<u>LU/288/17/DOC</u>	22 Beach Road & 3 Evans Gardens Littlehampton BN17 5HT	Application for approval of details reserved by condition imposed under planning permission LU/56/17/PL relating to Condition No. 3 (Noise report), 6 (Refuse management statement) & 8 (Grease trap specification)
----------------------	--	--

Environmental Health: I refer to Document Reference 131718 Rev A, prepared by Ned Johnson Acoustic Consultants Ltd, in respect of the proposed ventilation system and cooling fans to chillers at Pizza Hut, 22 Beach Road, Littlehampton. The report identifies that 'break out' noise both from the flue system and chiller fans is too loud and does not suggest mitigation methods which will satisfactorily deal with this in such a way as this will avoid detriment to the amenity of nearby sensitive receptors (See BS8233:2014, Code of Practice on Sound Insulation and Noise Reduction for Buildings referred to in this report). The assessment has, furthermore, been made on the basis that the most affected room will be on the first floor. However, the extent of the significant adverse effect of these new sources of noise means that this is also likely to adversely affect nearby second

PROPOSED REAR ELEVATION

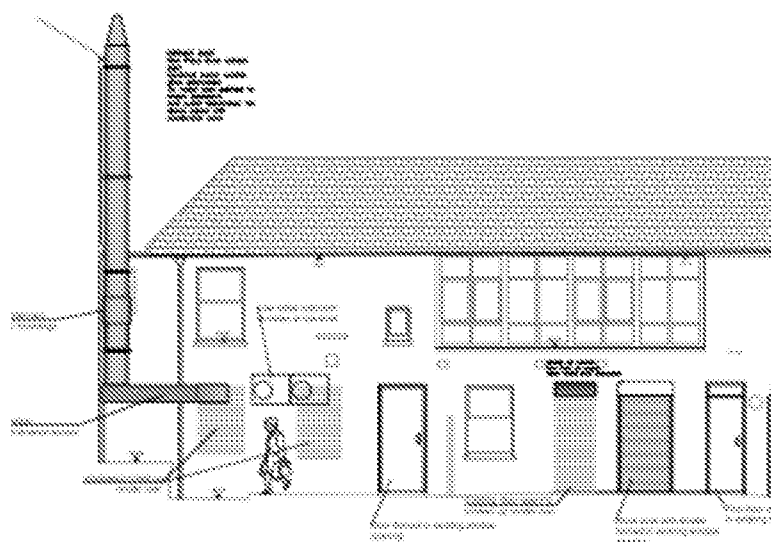
We cannot therefore accept this report as discharging Condition 3.
